Letter No. **A1/24310/2001**

Sub: CMDA - Planning Permission - Construction
of Residential/~~Commercial~~ Building at
**plot No.15, D.No.3, Poes Road, 4th Street,
Vannia Teynampet, in R.S.No.1562/4, Block
No.31 of Mylapore, Chennai**

Development charges and other charges to
be remitted - Regarding.

The Planning Permission Application/Revised Plan
received in the reference cited for the construction/
~~additional construction/resubmission~~ of **stilt, GF, FF&second
floor part with 4 dwelling units**
~~Residential/Commercial~~ building at the above referred site
at **Plot No.15, D.No.3, Poes Road, 4th Street, Vannia Teynam
pet, in R.S.No.1562/4, Block No.31 of Mylapore**

**PROPOSED RESIDENTIAL FLATS AT,**  
**DOOR NO-2, POES ROAD, 4<sup>th</sup> STREET,**  
**TEYNAMPET, CHENNAI - 18.**  
**NEW DOOR NO 3, PLOT NO:15**  
**MYLAPORE DIV**  
**R.S. NO: 1562/14**  
**BLOCK NO: 31.**

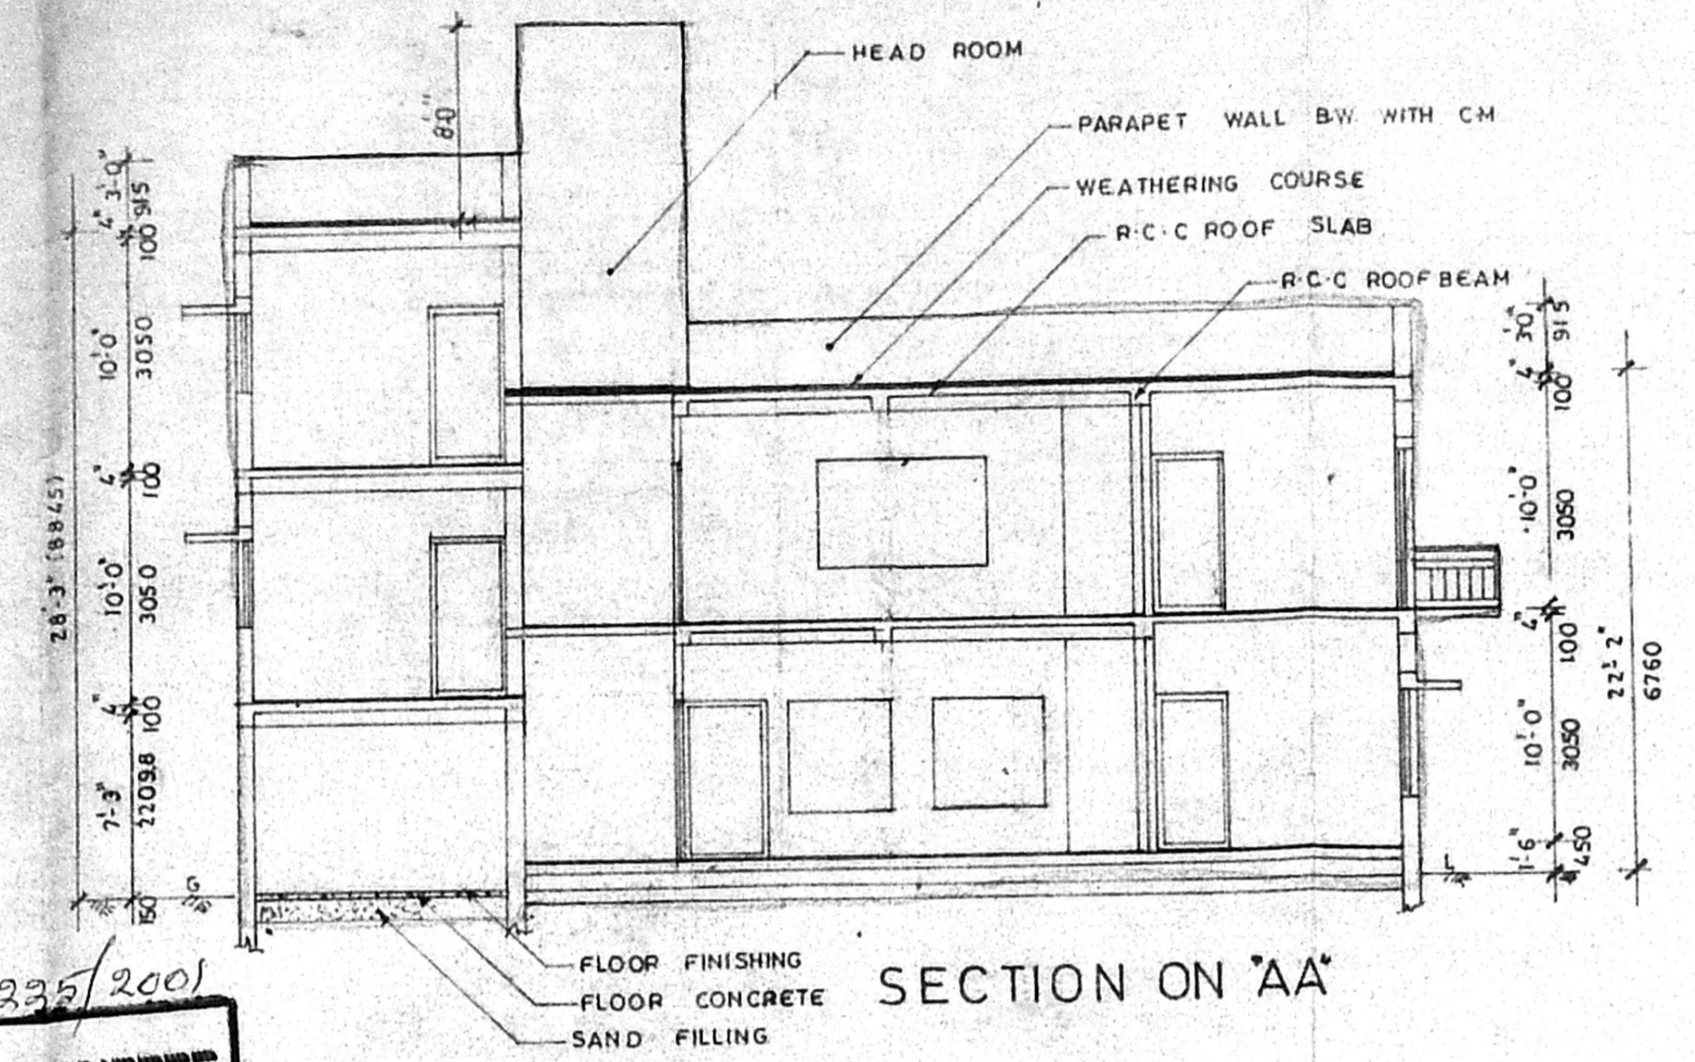
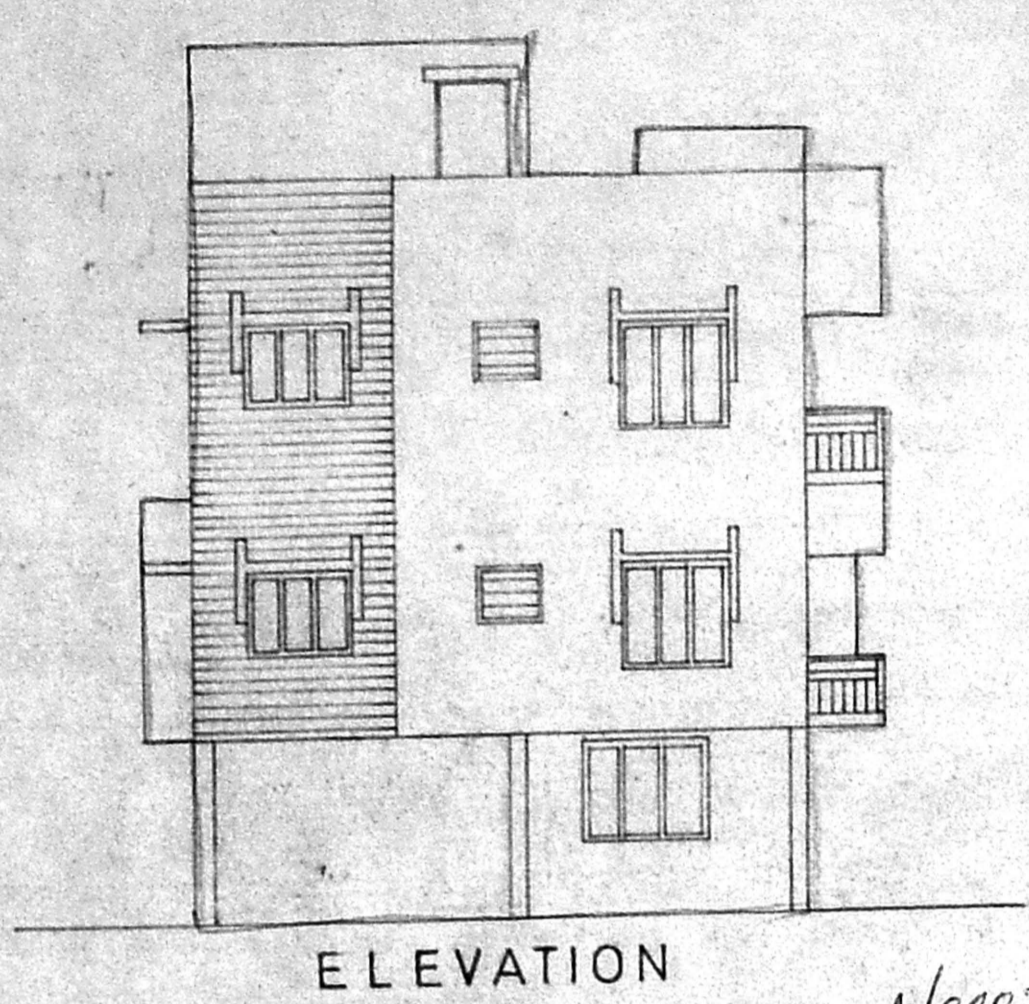
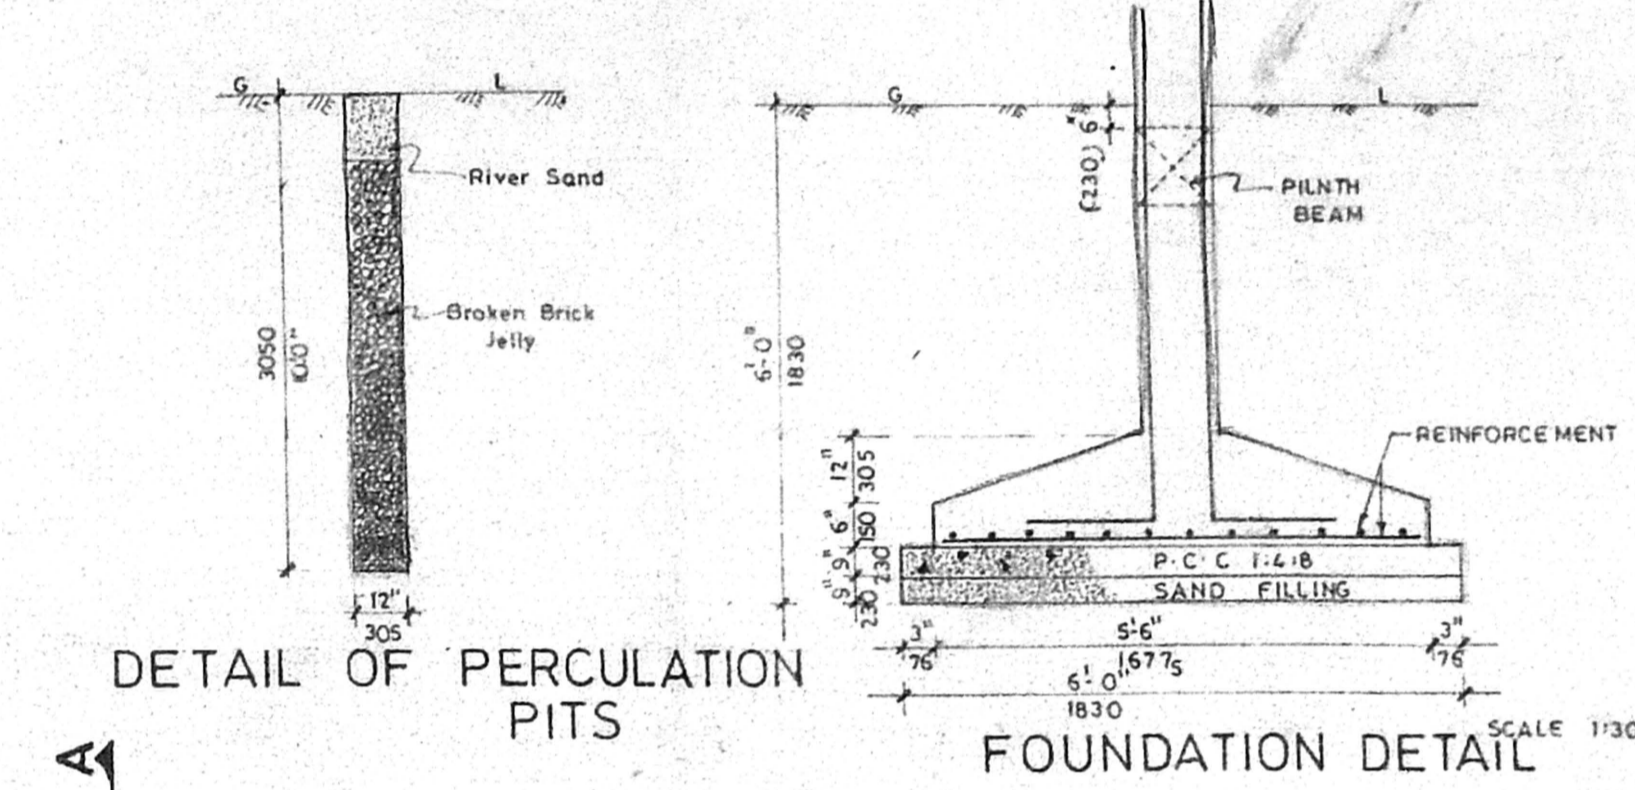
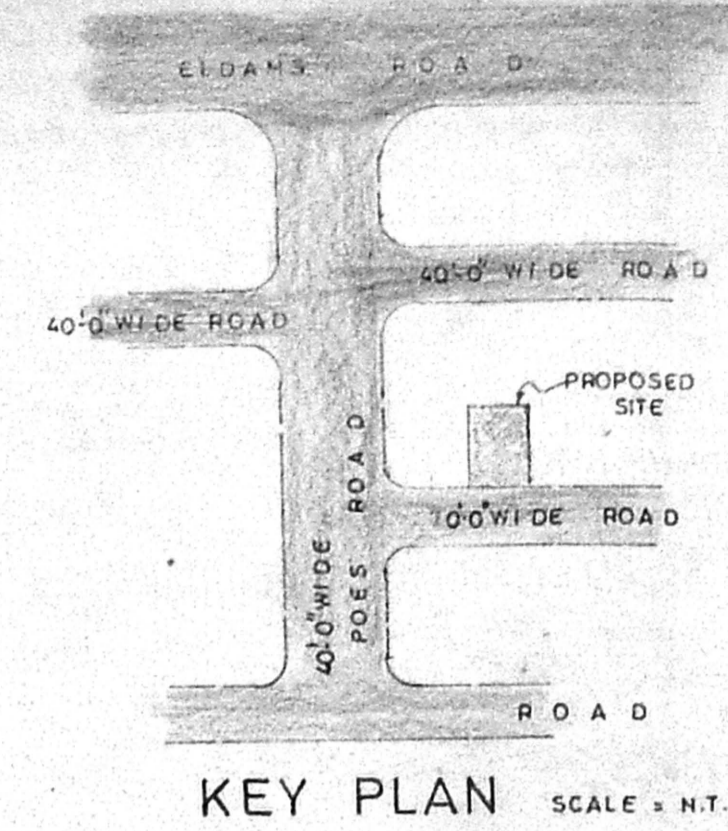
b. 6 copies of revised plan showing elevation tallying with//

//detailed floor plan.
